STATE OF NORTH CAROLINA
DEPARTMENT OF TRANSPORTATION

August 26, 2008

Subject: Notification of design change for the replacement of Bridge 311 over Lake Wheeler on SR 1379 (Penny Rd.), Wake County, Division 5, WBS 33351.1.1, Federal Aid Project No. BRZ-1379 (1), State Project No. 8.2408101, T.I.P. No. B-3917.

PROJECT REFERENCE NO. B-3917		SHEET NO. 5	
RW SHEET NO.			
ROADWAY DESIGN ENGINEER		HYDRAULICS ENGINEER	
Prepared in the Office of:			
701 Corporate Center Drive, Suite 475 Raleigh, NC 27607 (919) 854-6200 - (919) 854-6259 FAX			
GRAPHIC SCALE			
PLANS

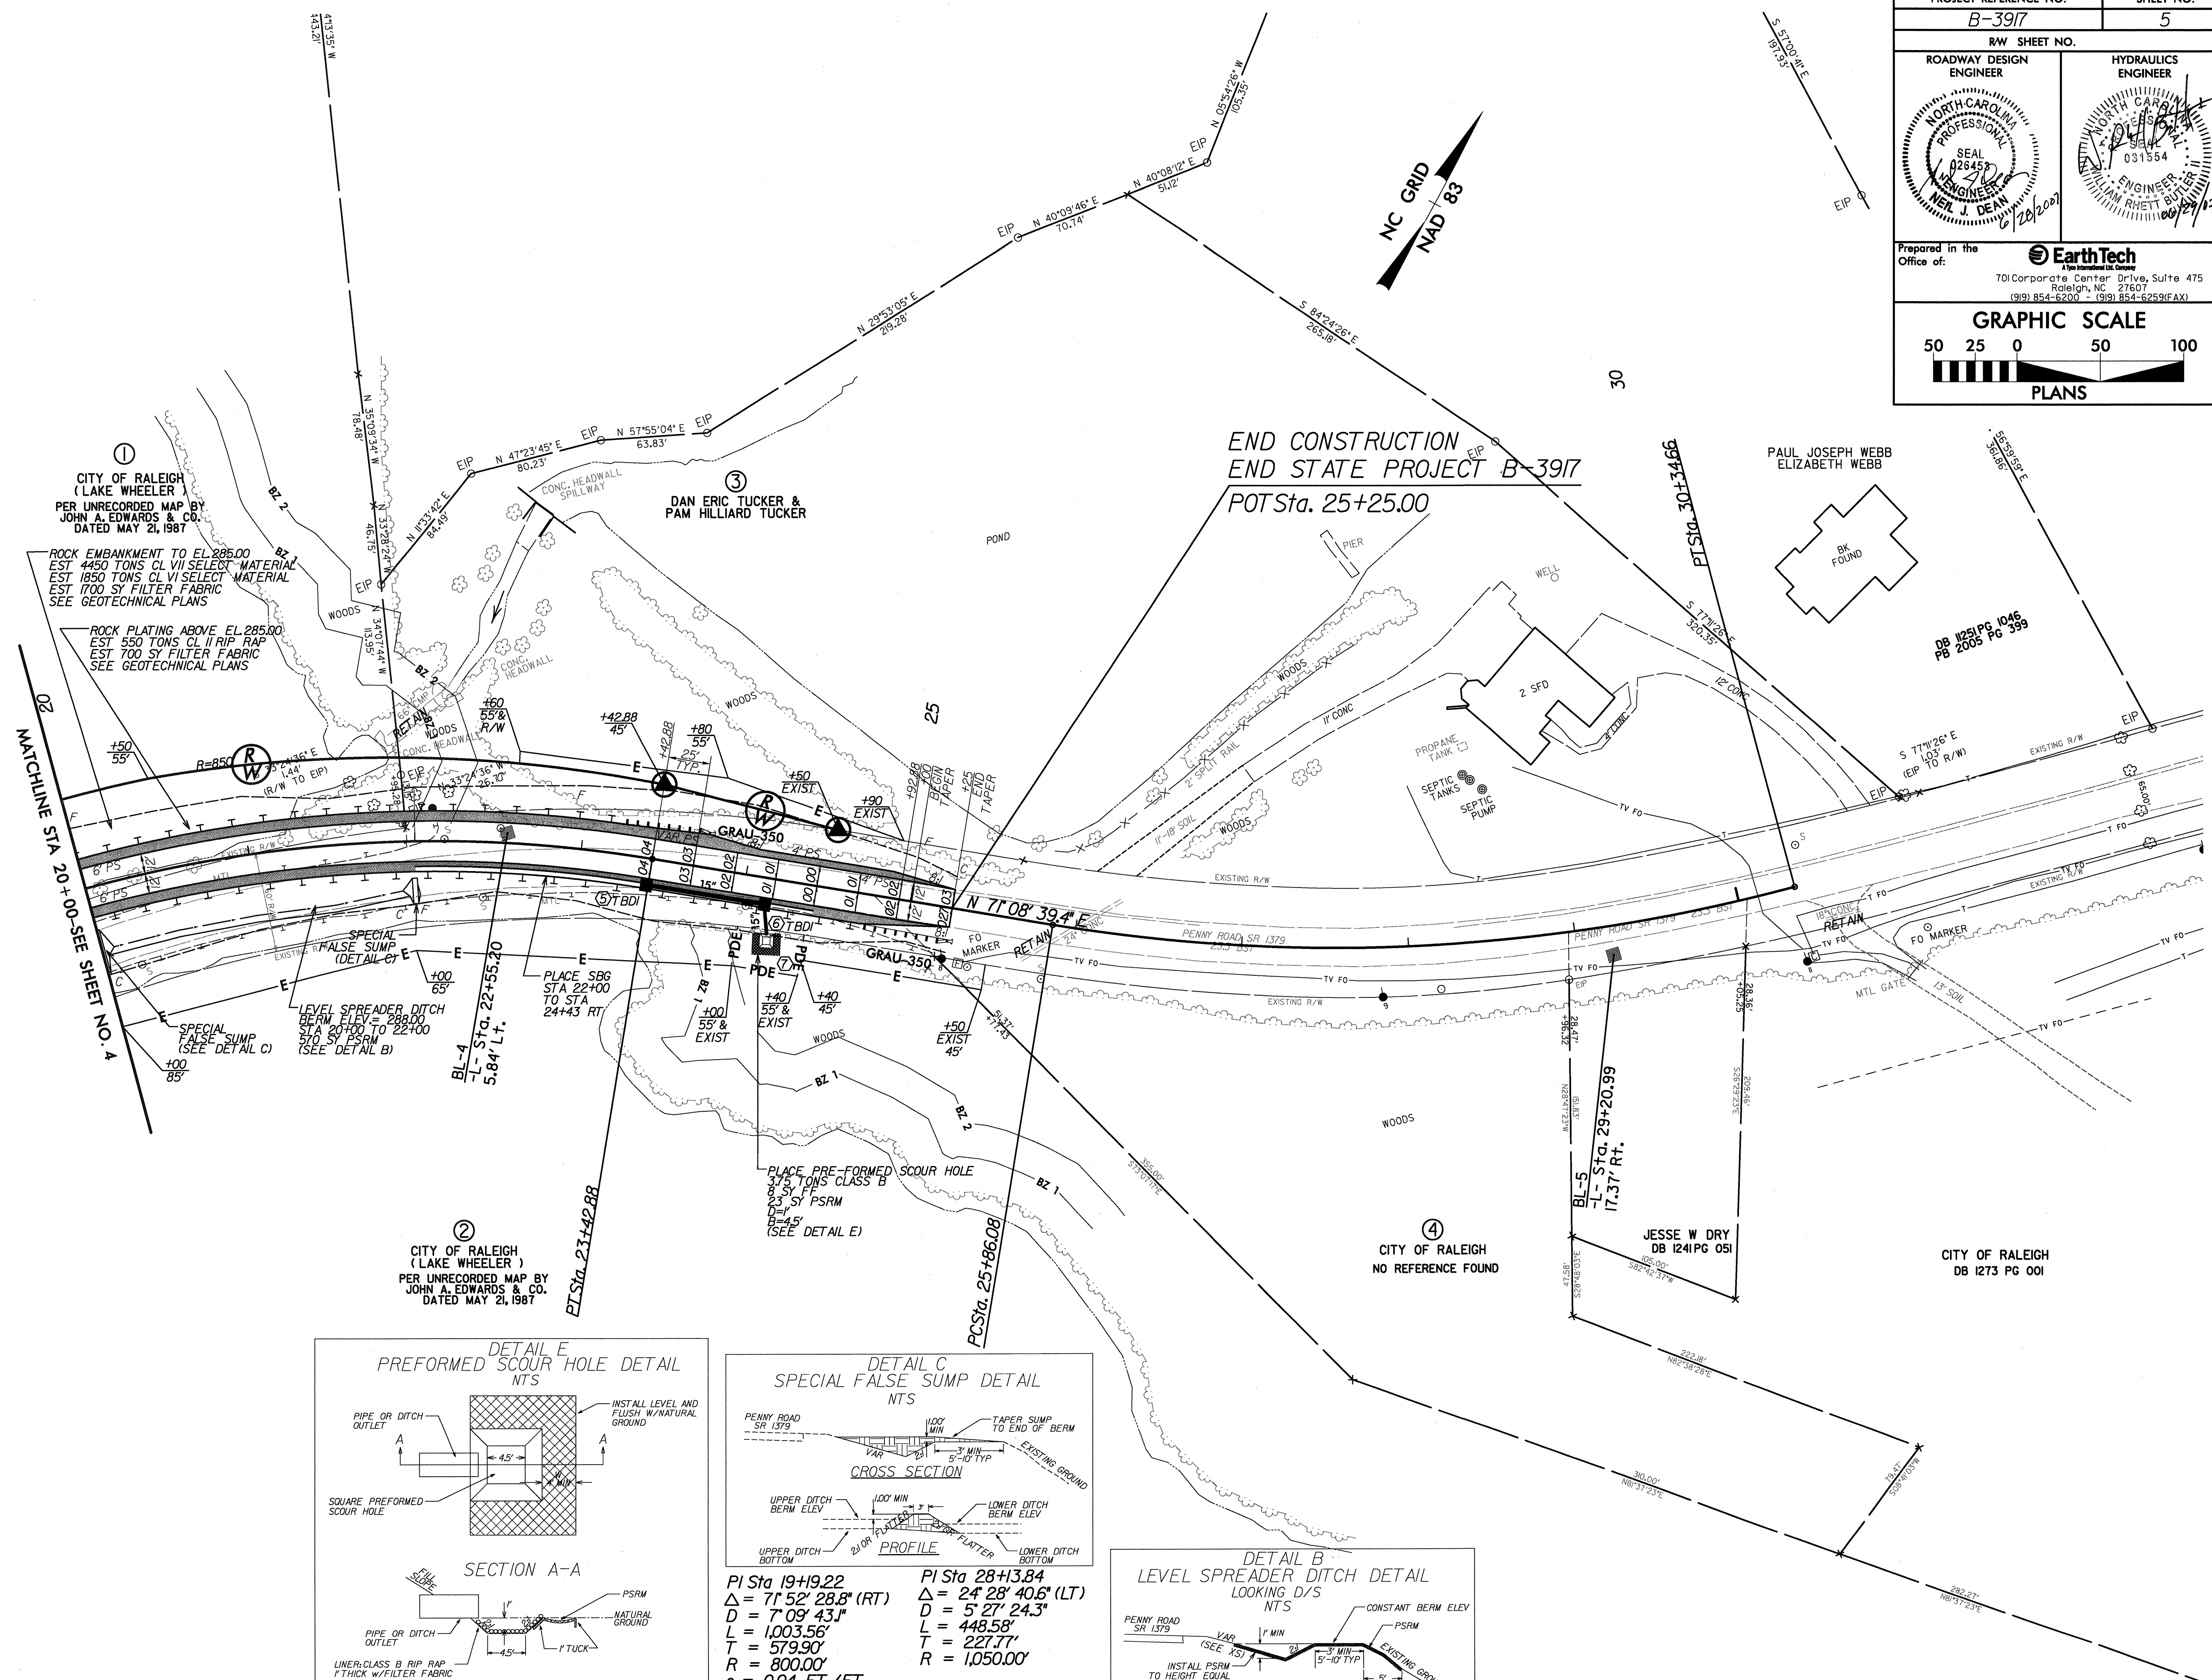
On July 8, 2008 North Carolina Division of Water Quality (NCDWQ) representative Rob Ridings met with North Carolina Department of Transportation (NCDOT) representatives Dan Duffield and Erica McLamb to discuss the ponding of water east of Site 5 (Design Plan Sheet 5, Buffer Permit Drawing Sheet 9 of 10). During this meeting it was determined that the water was not draining because a roadside ditch had been covered during the construction. Dan Duffield proposed reestablishing the ditch in its previous location to allow the water to drain. Rob Ridings agreed that reestablishing the ditch in its pre-existing location was allowable under the Neuse Riparian Buffer Regulations as long as non-erosive velocity was maintained. The reestablished ditch will meet the Neuse Riparian Buffer requirements for treatment and non-erosive velocity.

The buffer impacts were permitted to the easement of the project and this activity would occur within the permitted portion of the project area, therefore no additional impacts would be incurred (see attached Revised Buffer Permit Drawing Sheet 9 of 10 and Design Plan Sheet 5). Rob Ridings determined that the reestablishment of the preexisting ditch would not require a permit modification, but requested a letter of notification to NCDWQ with the revised permit drawings and plan sheets. There will be no additional impacts to jurisdictional streams or wetlands as a result of this activity.
